Our Case Number: ACP-323849-25

Re: The proposed development is for a mixed use development that seeks the regeneration and adaptive reuse of a strategic brownfield site, as part of the Limerick City and County Council 'World Class Waterfront revitalisation and transformation project' 'Cleeves Riverside Quarter' in the townland of Farranshone More in Limerick City.

Formal Observation / Objection

Re: Proposed Development — Cleeves Riverside Quarter / Cleeves Riverside Campus

1 Stonetown Terrace Level 01 GA Plan
1: 200

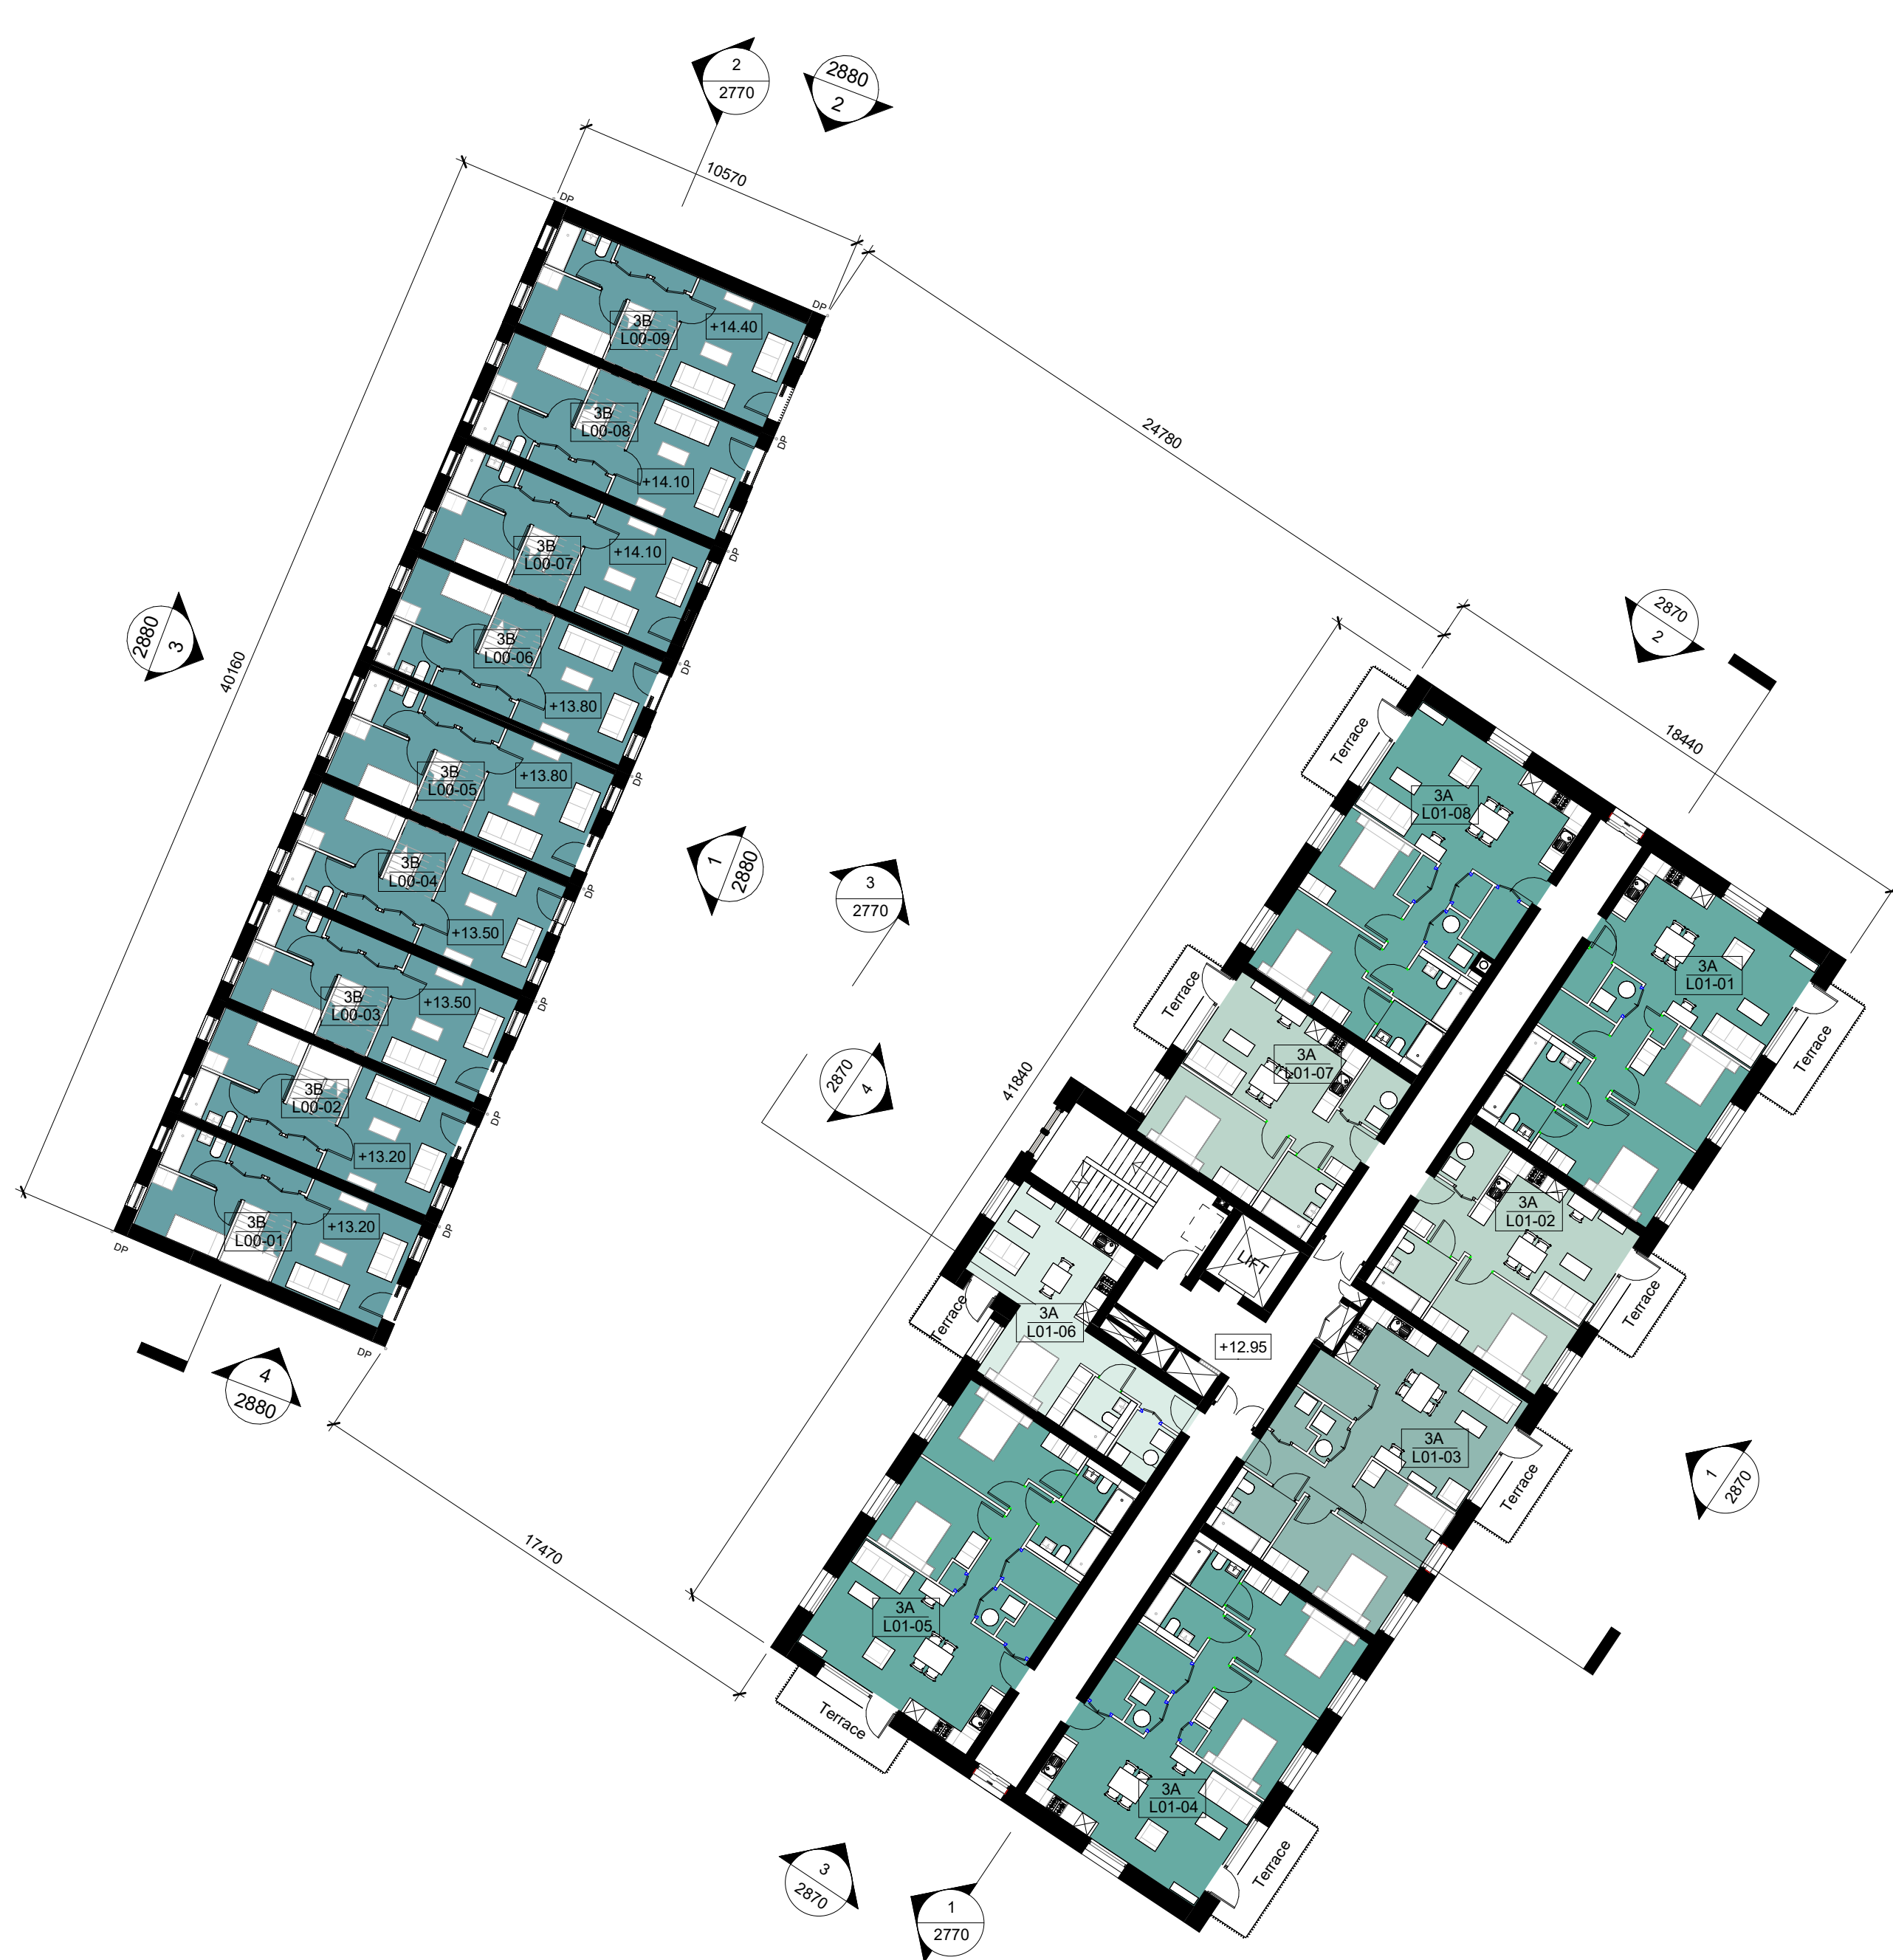
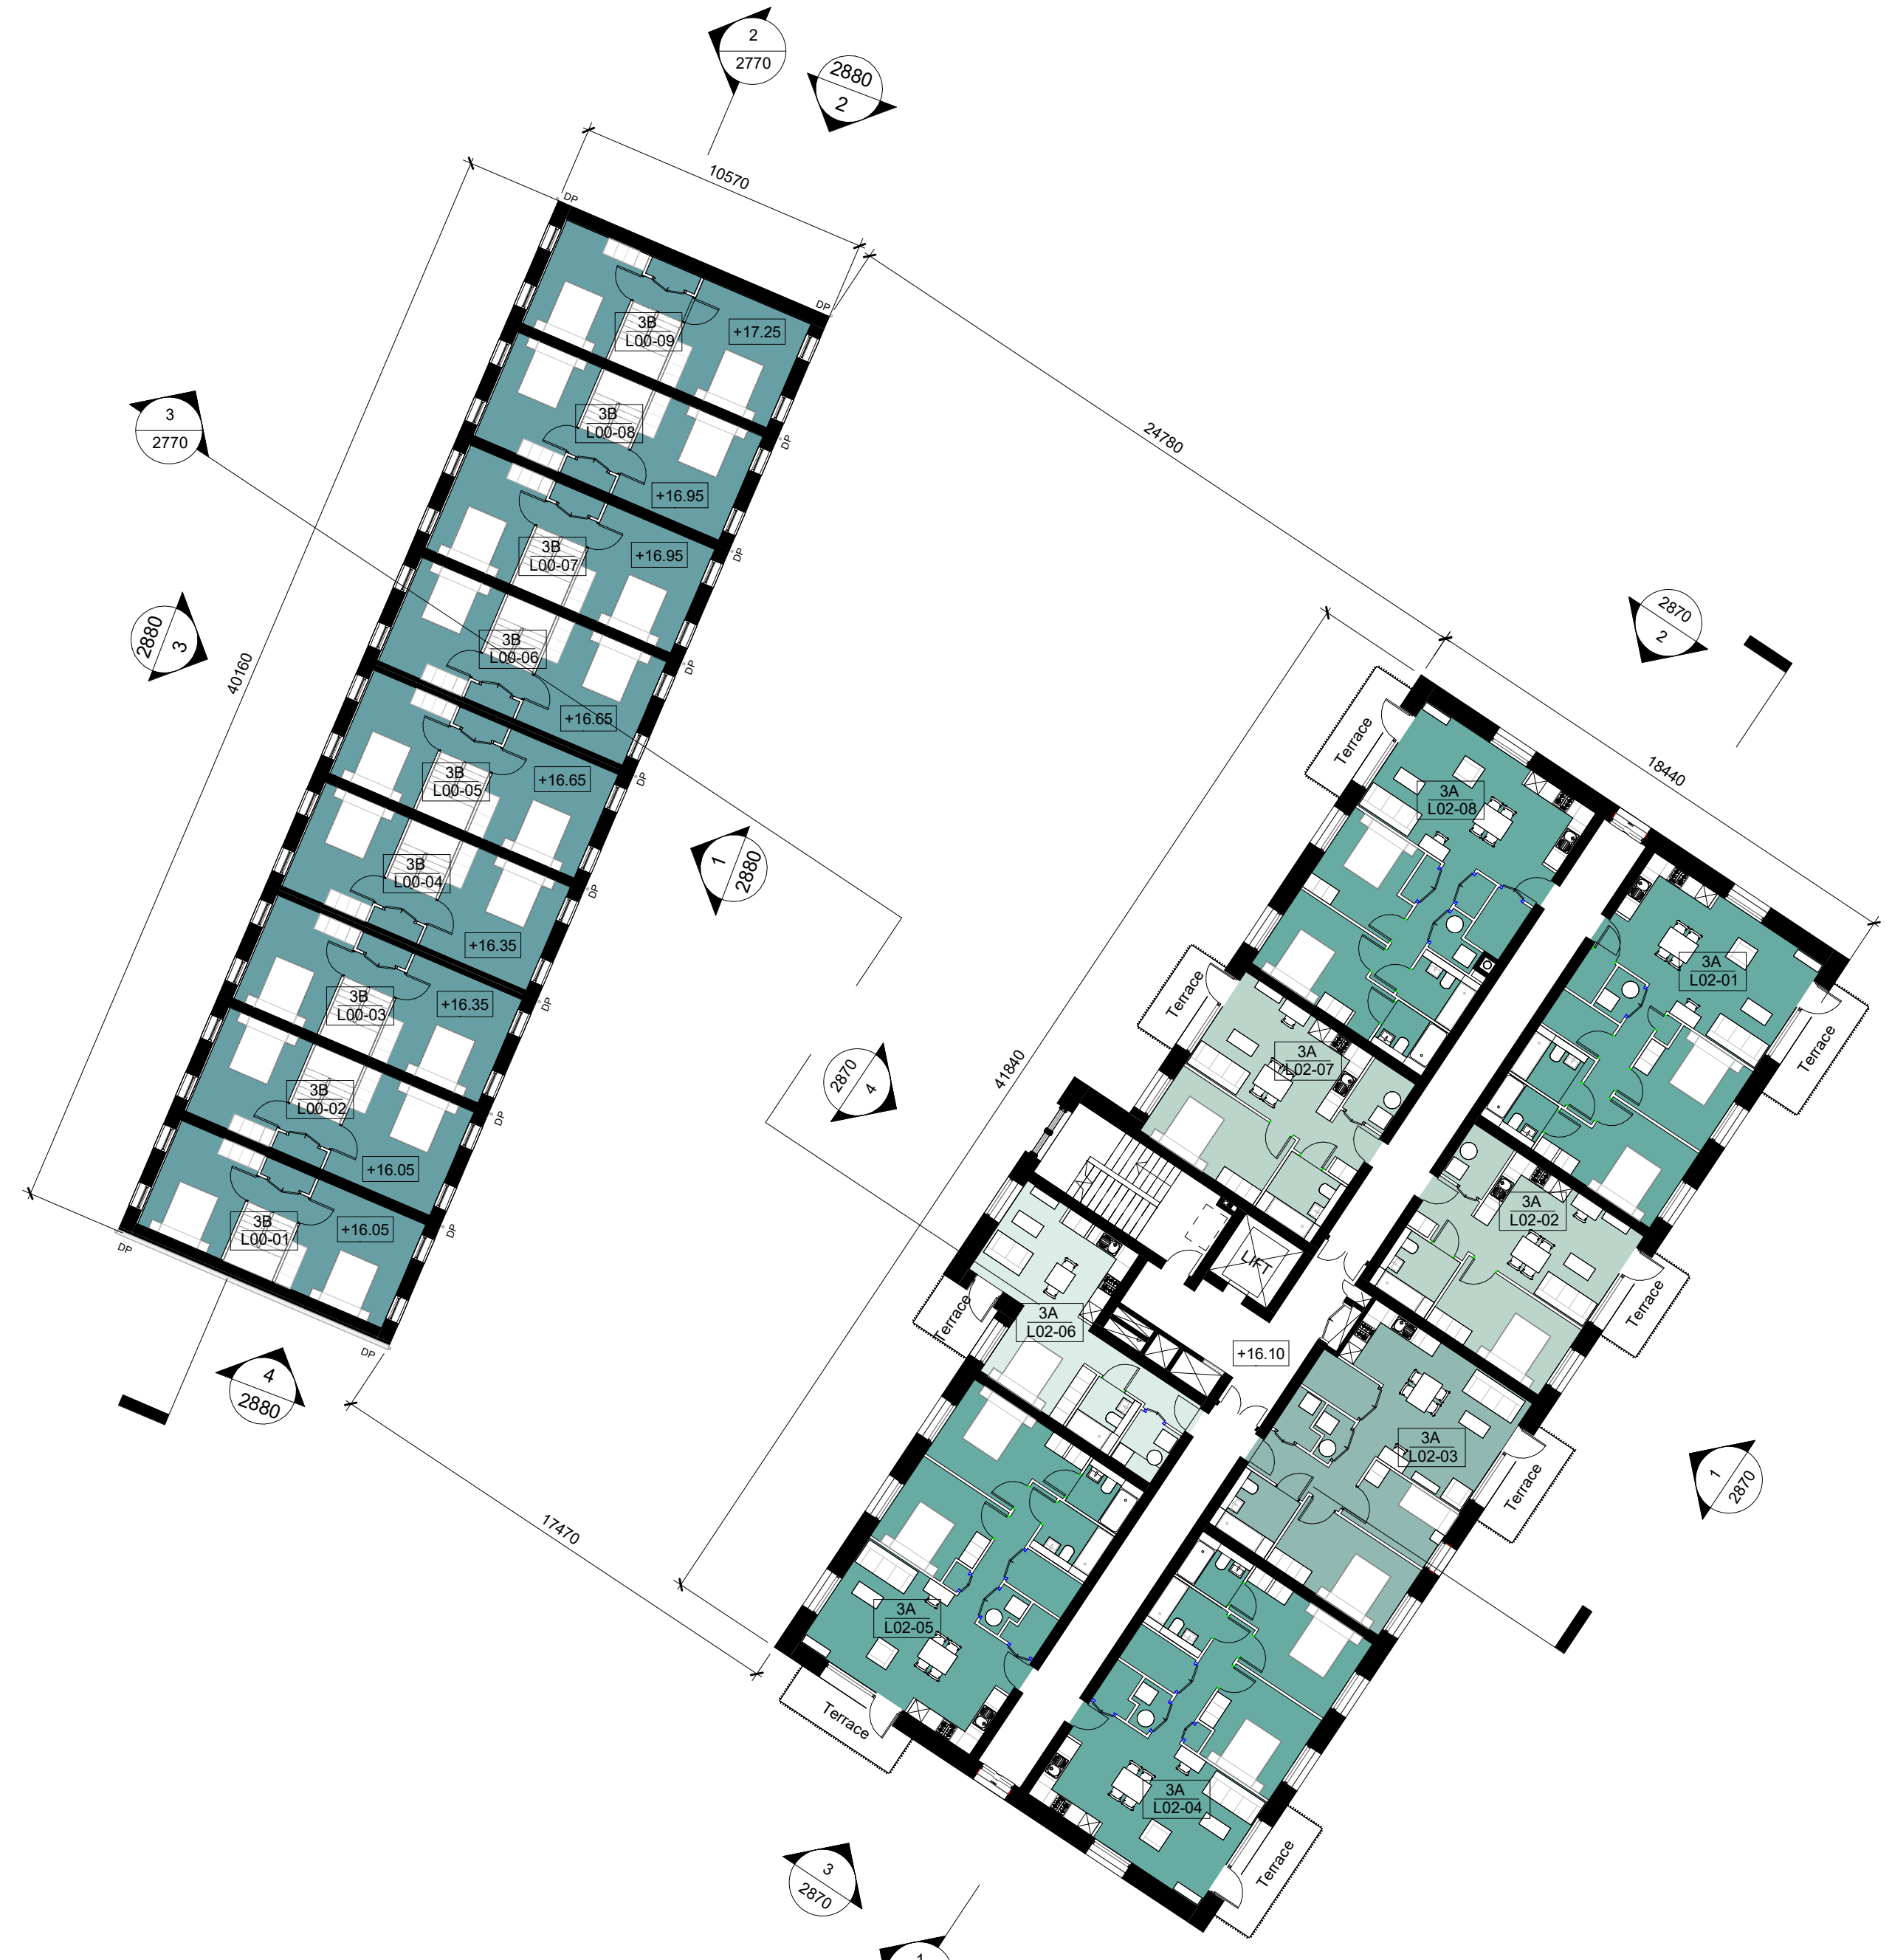
I finally received an incomplete reply to my correspondence on the 25th of November 2025 which informed me that a 21 meter, five story apartment building would be built 12.2 meters from the rear of my house. This reply only came when the planning application had been lodged with An Coimisiún Pleanála. This clearly shows zero prior consultation as the views and concerns of myself and local residents were neither invited or considered. We were denied the necessary information to properly formulate and express our concerns .

2. The Stonetown Terrace development is clearly inappropriate for its location. The five-storey development is towering over the two-storey family home residential areas of Clanmaurice Avenue, Clanmaurice Gardens and Strandville Gardens. It is towering over the largely two storey family development at Landsdowne Hall. The development is visually insensitive and obtrusive.

This correspondence was created in December 2025. It is quite clear from observation of the site that the five-storey block development will have a major impact on daylight. Standing at the rear of my family home it is patently obvious that a 21-metre monolithic block within 10 metres of my house clearly blocks sunlight. At the rear of our premises is a sunroom which gets the morning sun and clearly with this development in place the sun light would be effectively blocked.

- Limit buildings within 30m of Clanmaurice Ave. to 3 storeys
- Step back higher elements; vary rooflines
- Stronger integration of industrial heritage and material diversity
